CITY OF ALBUQUERQUE

**RE: Cuatro Development
Grading & Drainage Plan
Engineer's Stamp Date 9-17-2014 (File: J14D173)**

Based upon the information provided in your submittal received 9-17-14, the above referenced plan cannot be approved for Preliminary Plat until the following comments are addressed:

VICINITY MAP J-14

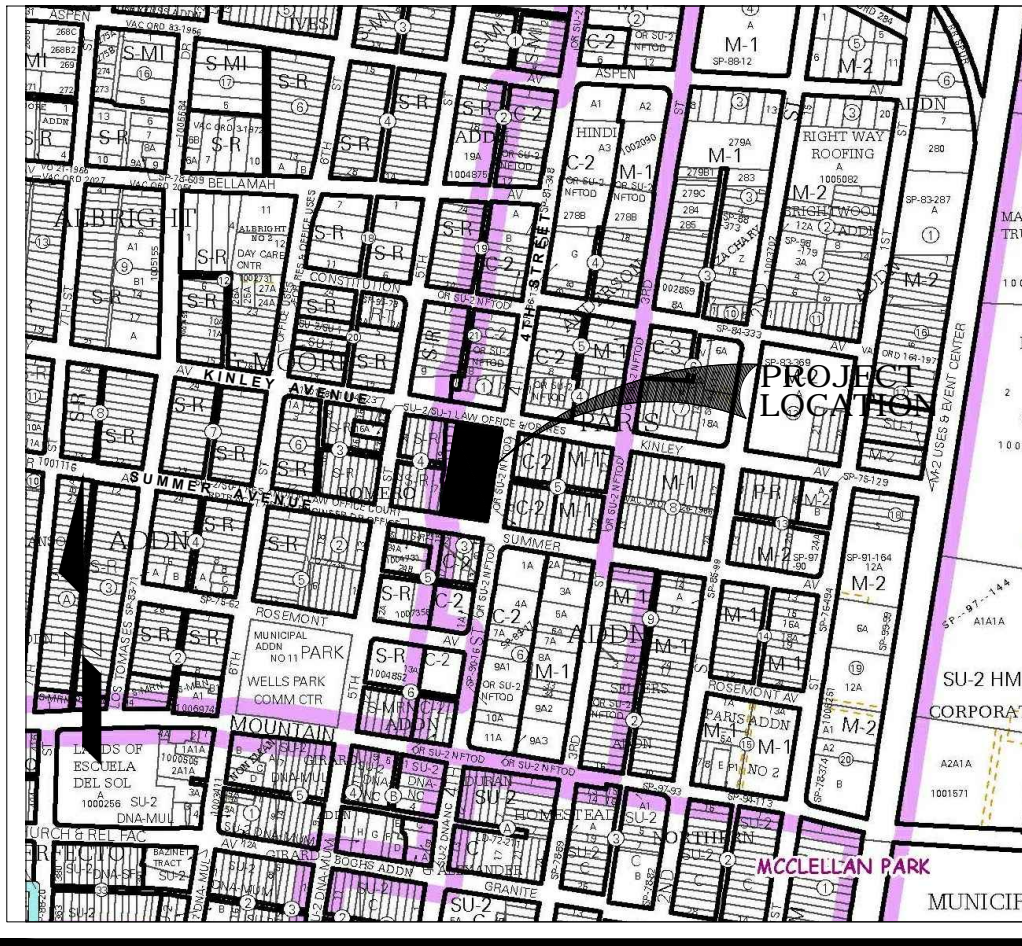
1. Street names are not legible on Vicinity Map.
2. Use larger scale of Flood Insurance Rate Map to show limits of flood plain (SFHA) and proximity to site.

GRADING PLAN
SCALE: 1" = 10'

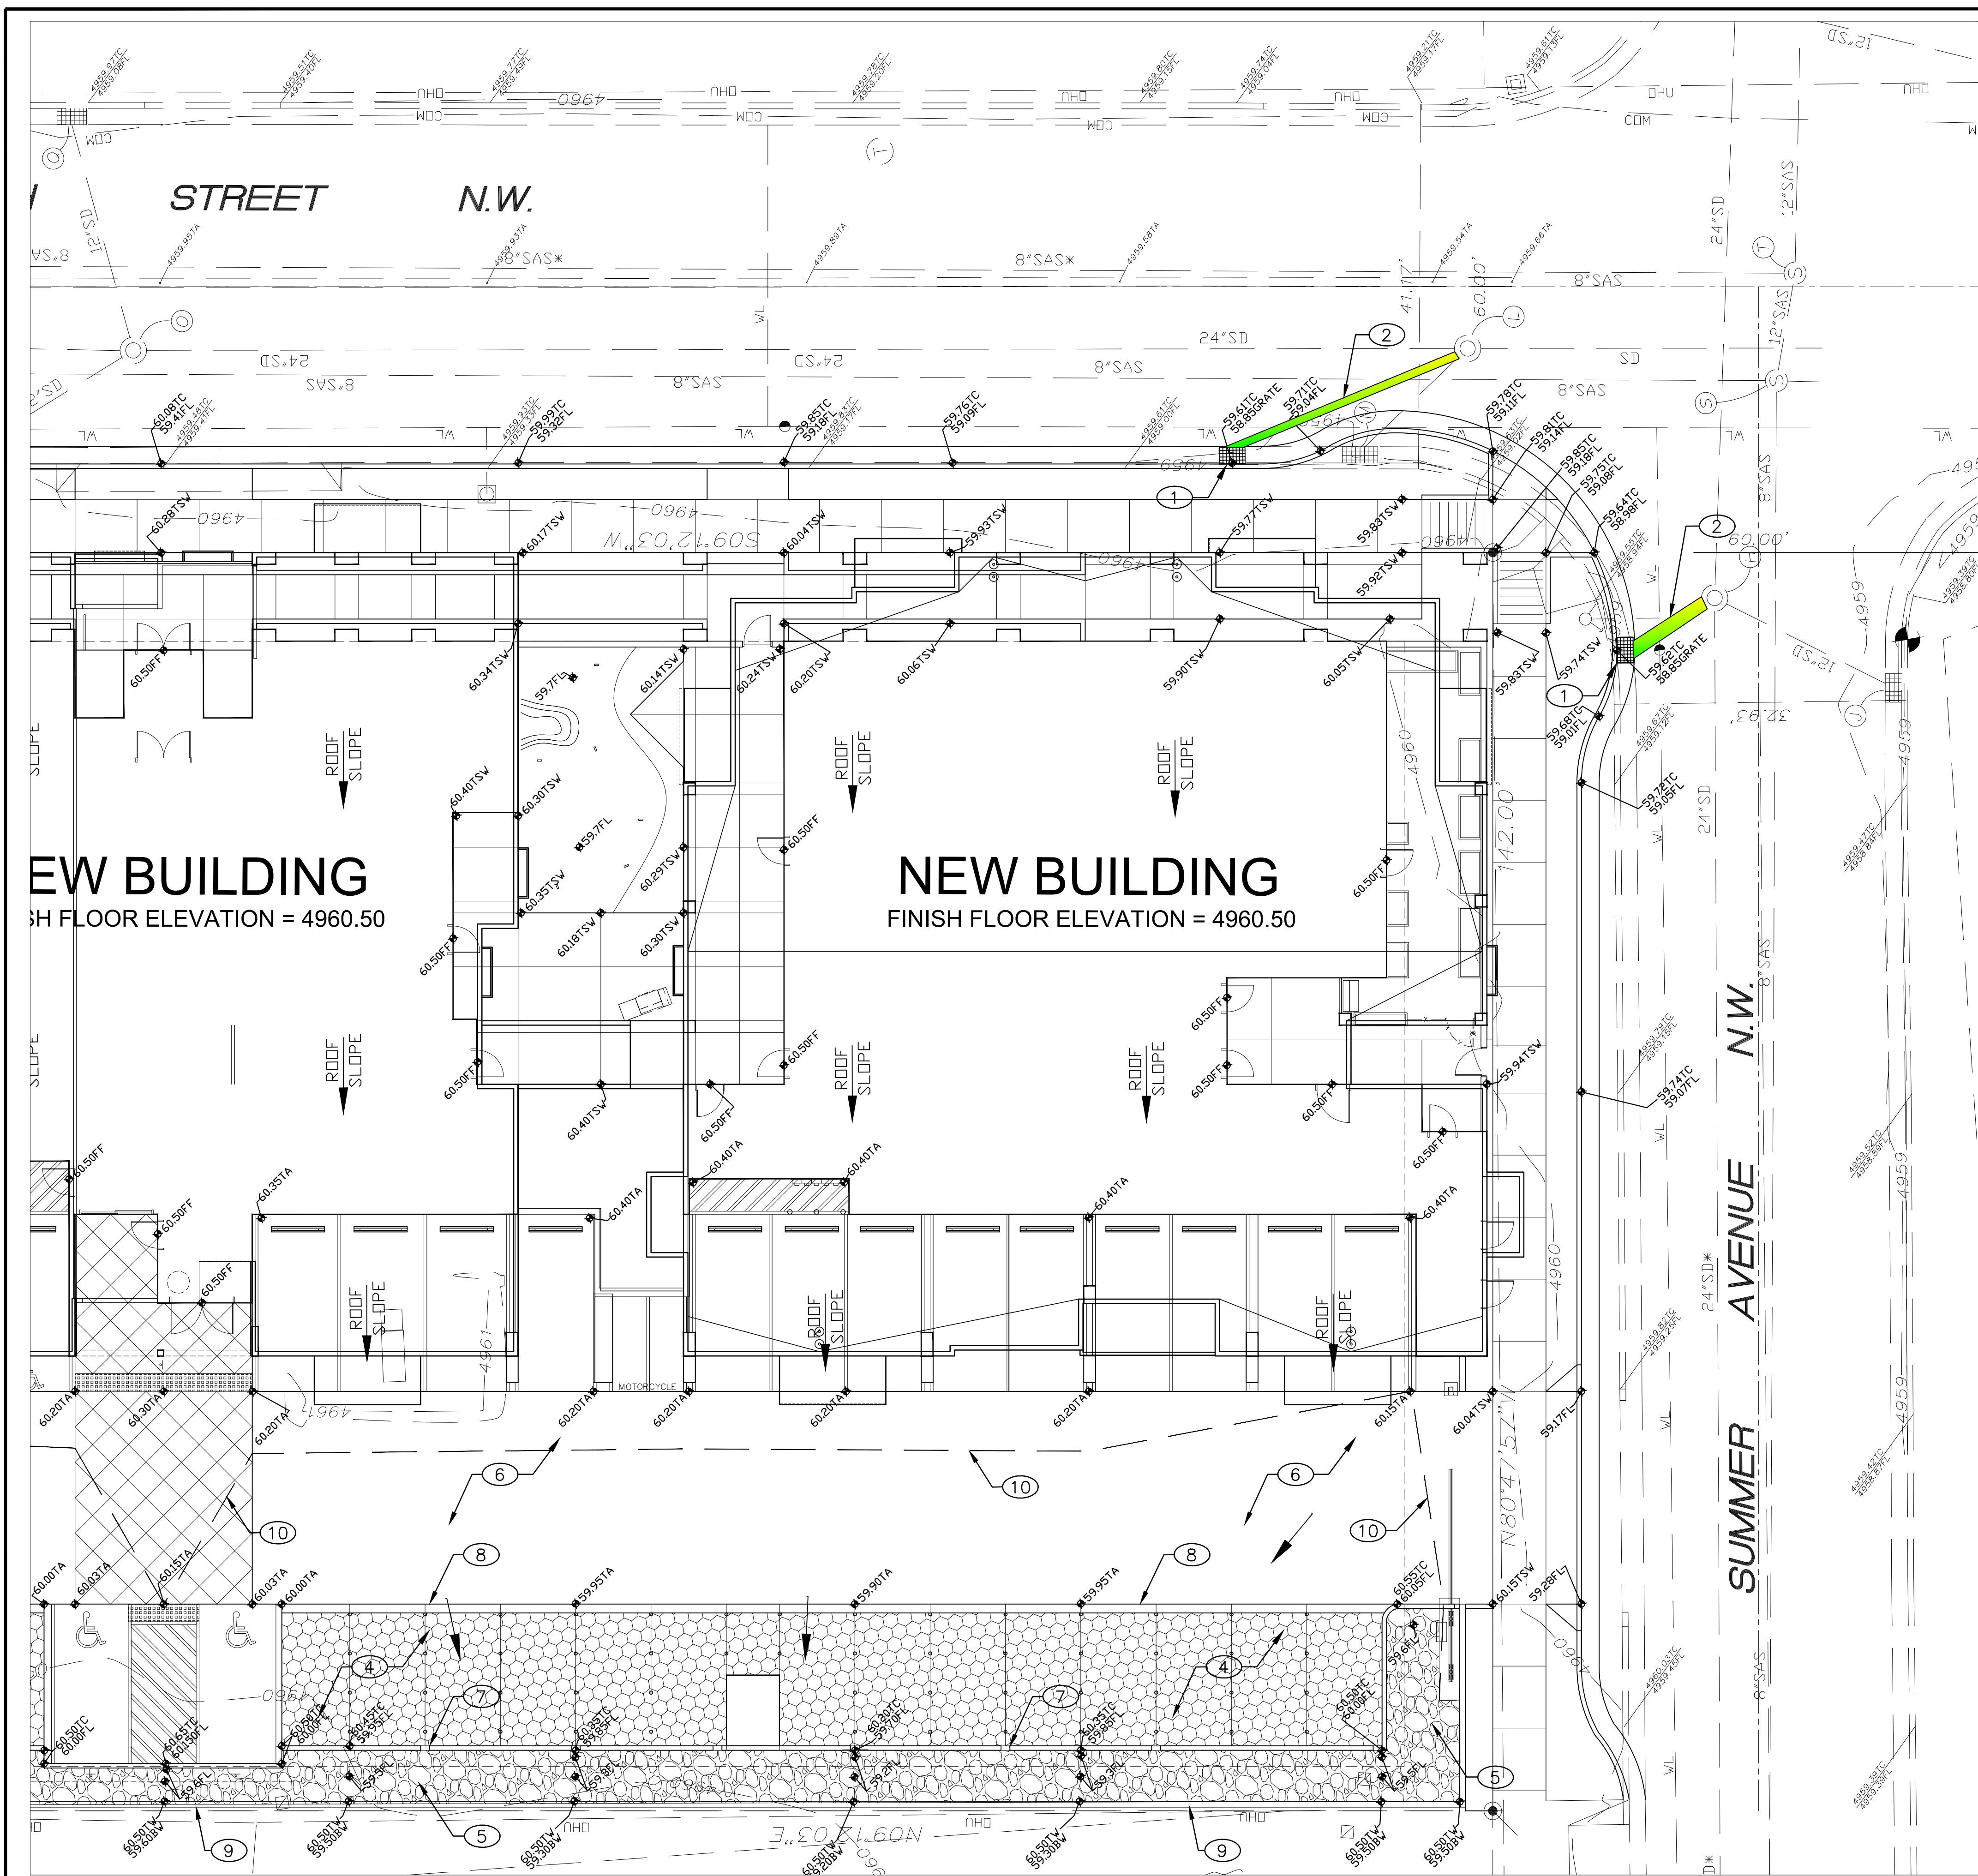
5. Presently there is a Single Type-A inlet at SE corner of site, and is proposed to be replaced with a Single Type-C inlet, which has less capacity. In order to not reduce the capacity of the inlets, it must remain a Type-A.

6. The minimum size of laterals is 18" dia.
7. Since laterals cannot tie into manholes at an acute angle a new manhole is needed at the 4th street connection.

8. The manhole in Kinley and 4th is most likely a 4' dia MH, and would not be able to accommodate the three Storm Drains as shown on the plan. A new manhole will be needed in 15" diameter SD.

9. Turn off architectural layers, showing only features pertinent to the drainage plan. Show only the roof limits and the building envelope limits only at the ground level. Are there exterior spaces between the buildings? If so, indicate with flow arrows the intended drainage scheme.

10. Note features such as walls, columns, planters and curb adjacent to the sidewalk. What are blank areas in the porous pavement? What is the feature shown in NW corner of site? Trash enclosure?

11. Indicate location of roof drains, if any.

EROSION CONTROL PLAN

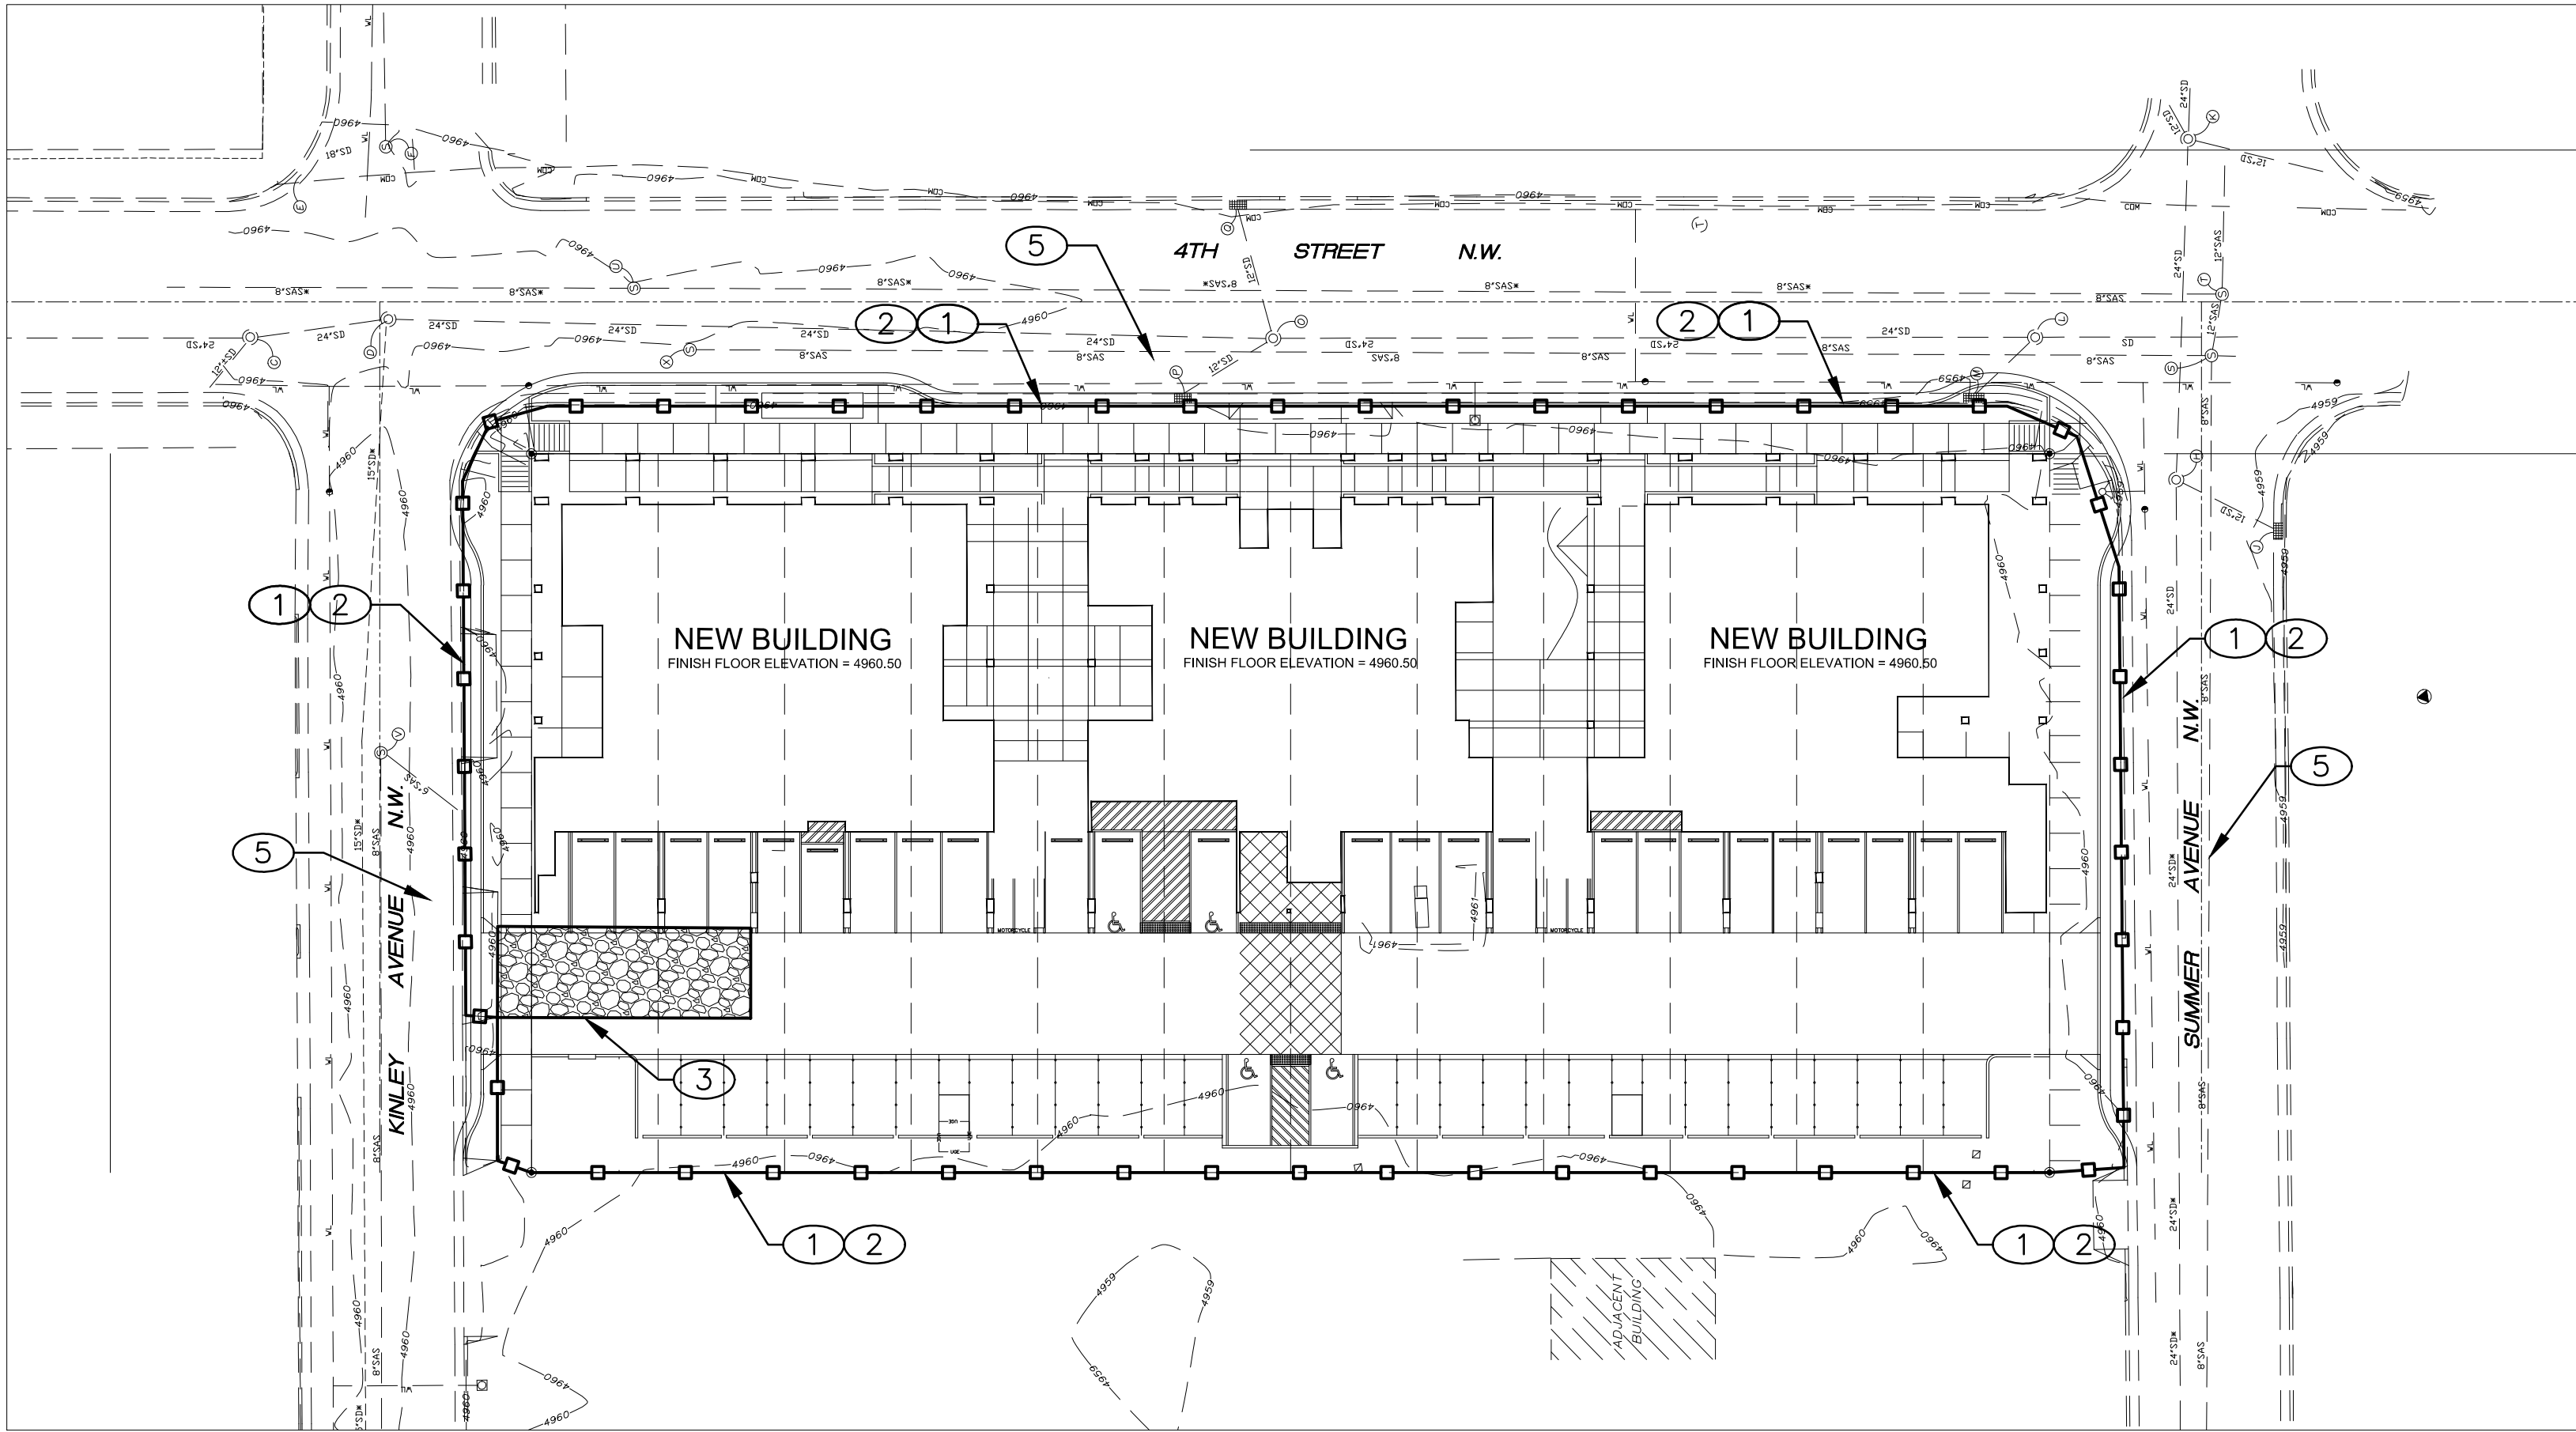
3. Renumber sheet 1-4, with the Erosion Control Plan being separate from the Grading and Drainage Plan Set.
4. City Storm Facilities Maps show there are two (2) storm drains in 4th Street, with the inlets midway between Kinley and Summer tying into the further storm drain. On the same note, records do not show the size of the SD along Kinney, and the SD in Summer is noted at "UNKNOWN". These Storm Drains will need to be field verified during construction.
